North of Sefter Road, Pagham – P/88/22/DOC Comments Tracker				Initial Issue Date: 12-10-2022 Issue Date: - Revision 1.2	
	ADC Drainage Comments 11-10-22	Applicants Response	ADC Drainage Comments 18-11-22	Applicants Response	ADC Drainage Comments 25-01-23
I hereby confirm the surface water drainage design and maintenance manual is satisfactory and recommend discharge of conditions 10 & 12.					
ADC Drainage Comments 24-05-23					
The updated information supplied April 23 reflects on the variation from the geocellular tank reverting back to an open surface water basin (Ref:5) with the footpath conflict issue removed. I understand the matter of the footpath routing will be reviewed on the future phasing.					
We are satisfied that all comments previously raised are closed (see below).					
The updated drawings, supporting information and calculations are acceptable.					
	Initial/Planning:

| 10768/1637     | P5   |

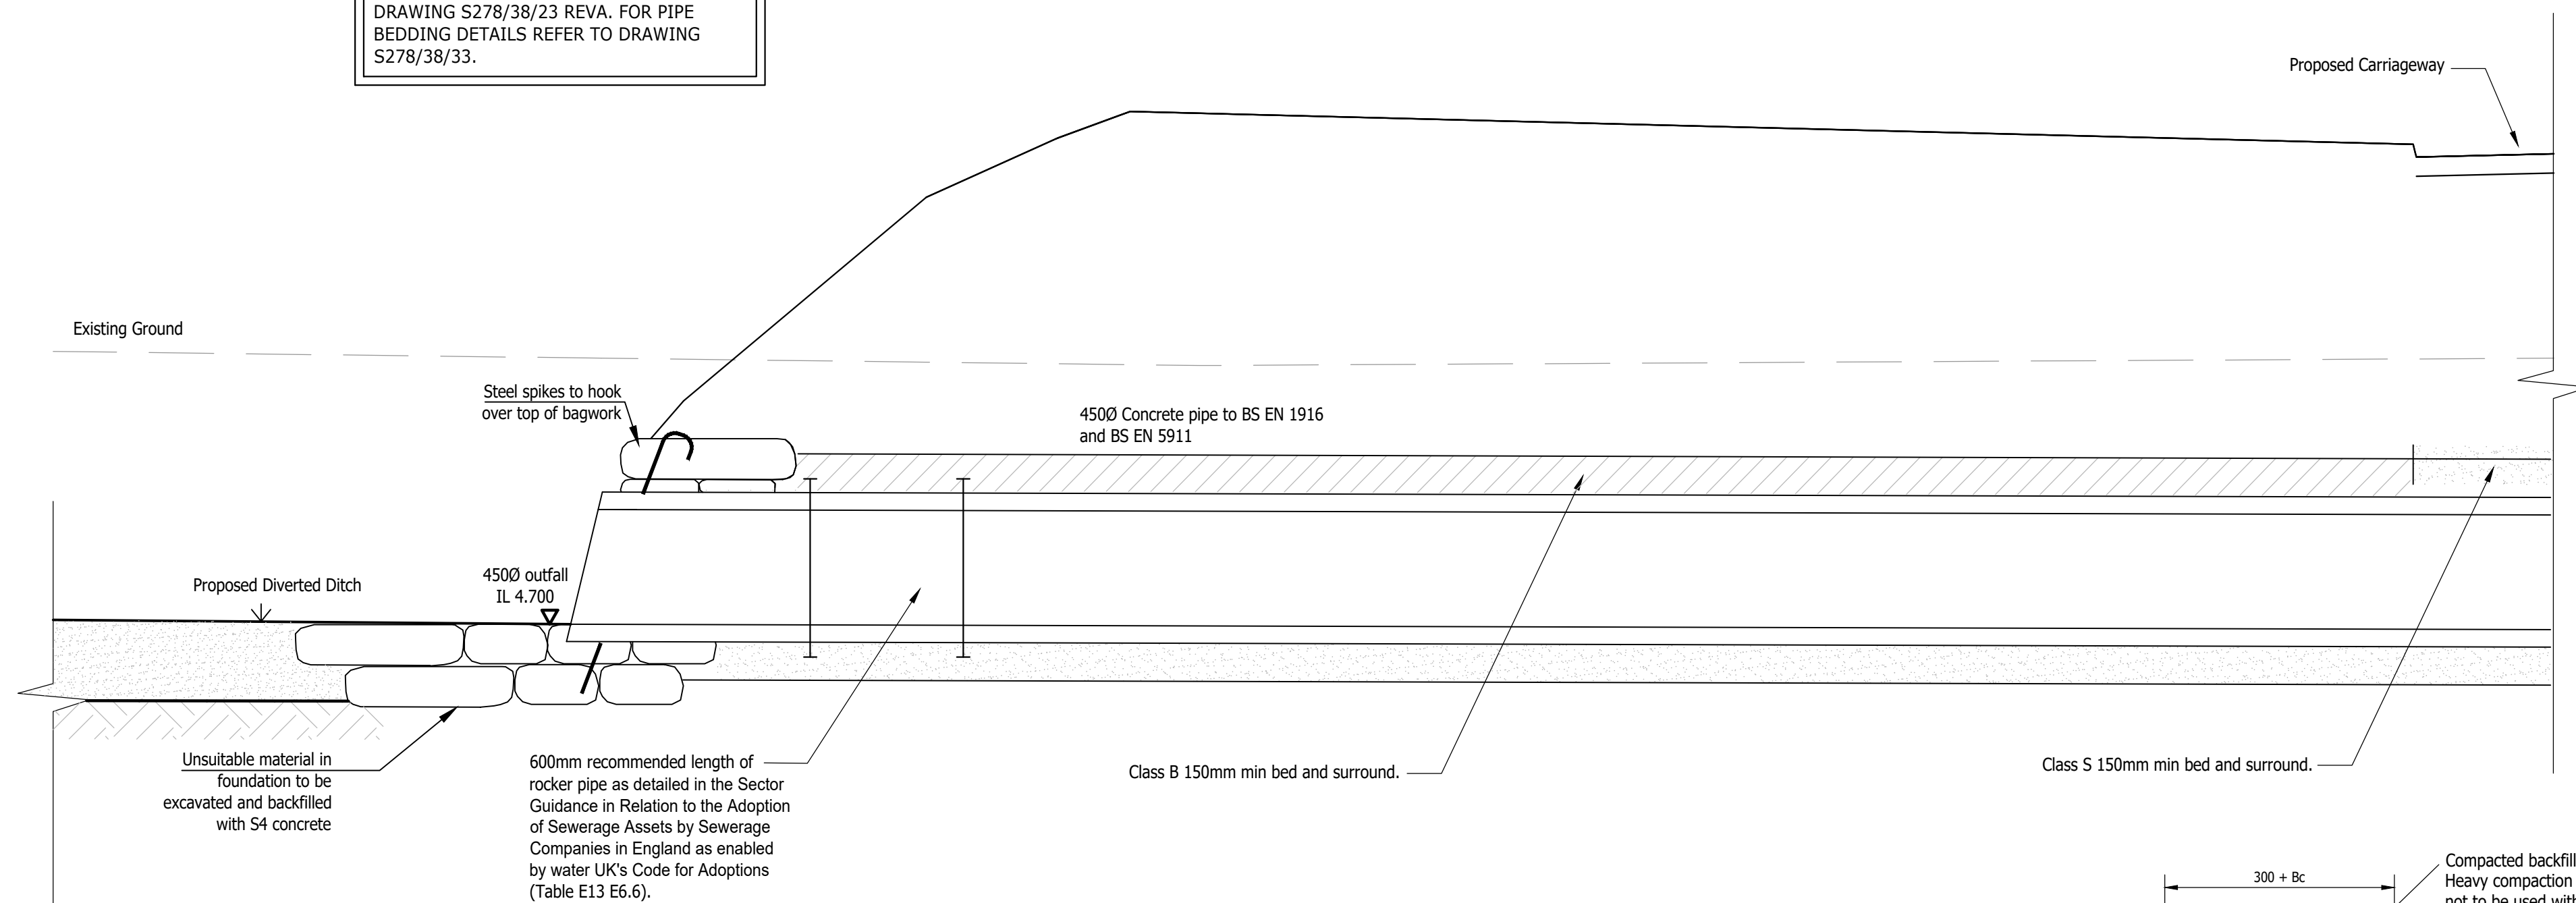
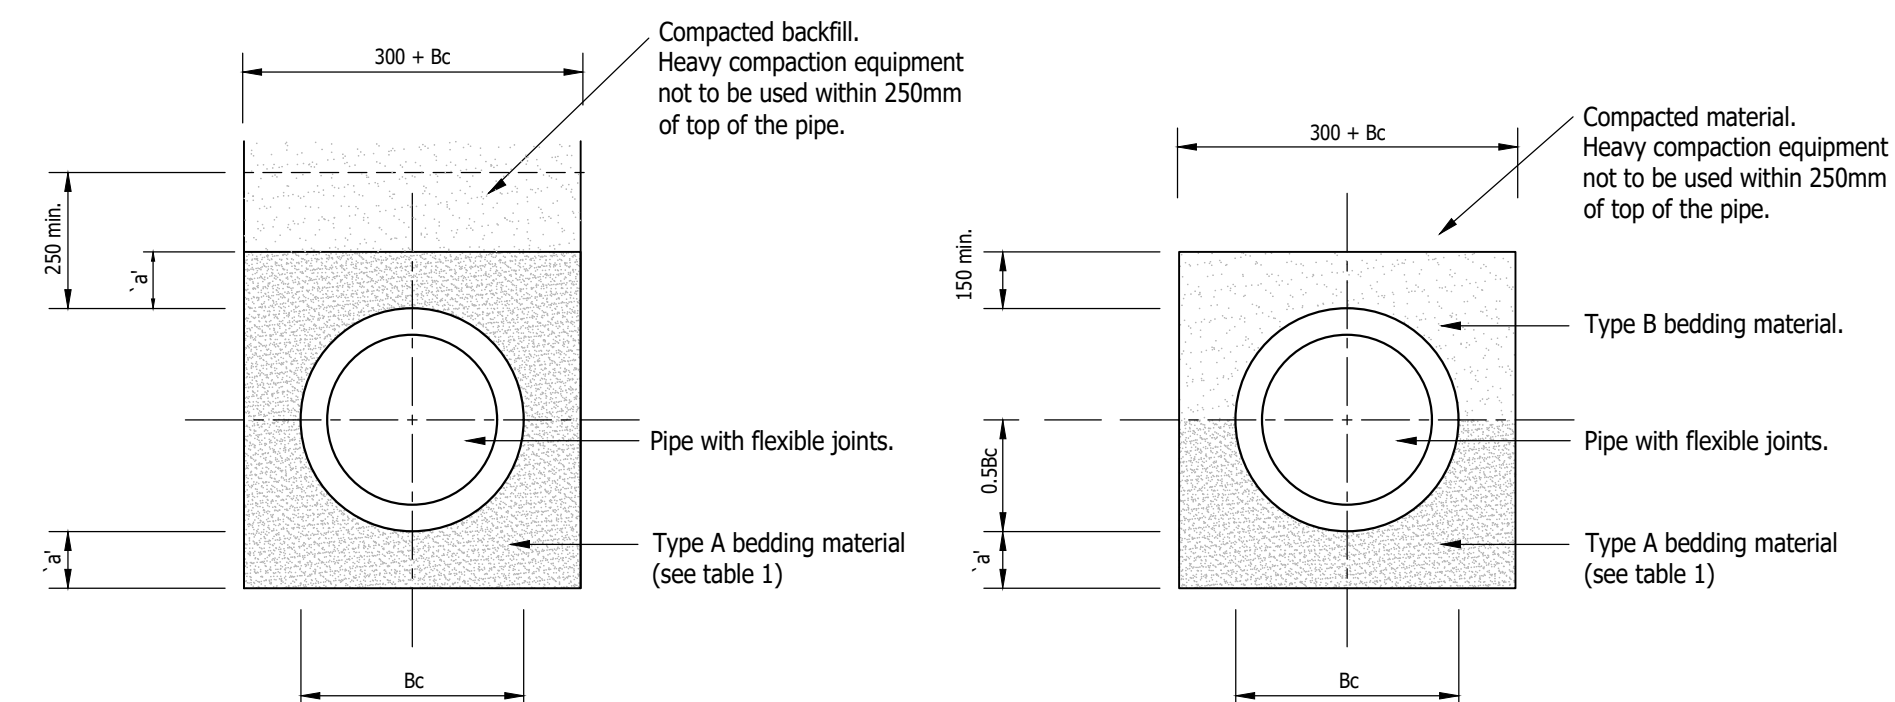
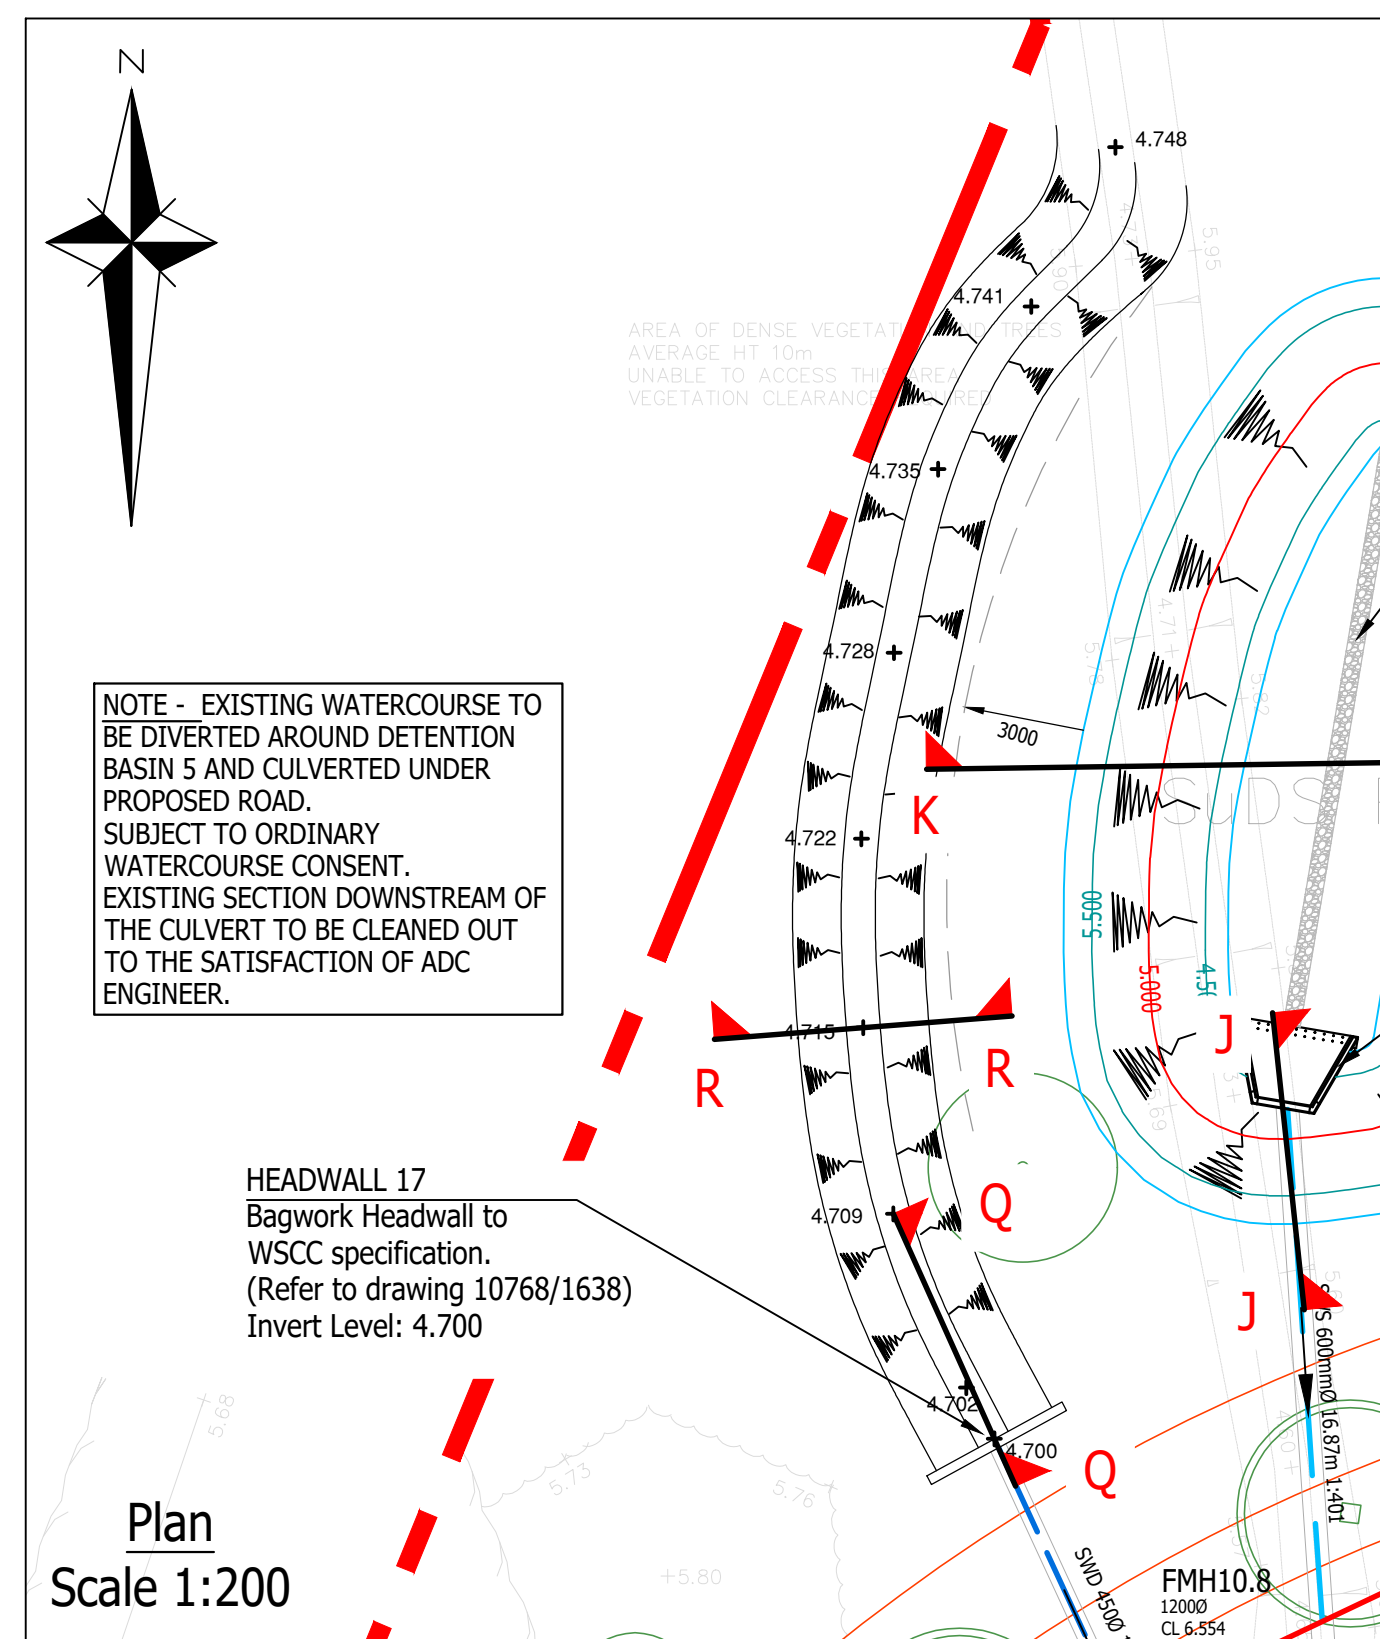
10.	With reference to drawing 1602/P6 the buffer in between the diverted watercourse and SW basin 5 does not comply with the minimum 3.0m.	Proposed diversion and pond orientation adjusted to comply with 3m requirement.	Agreed and closed.	-
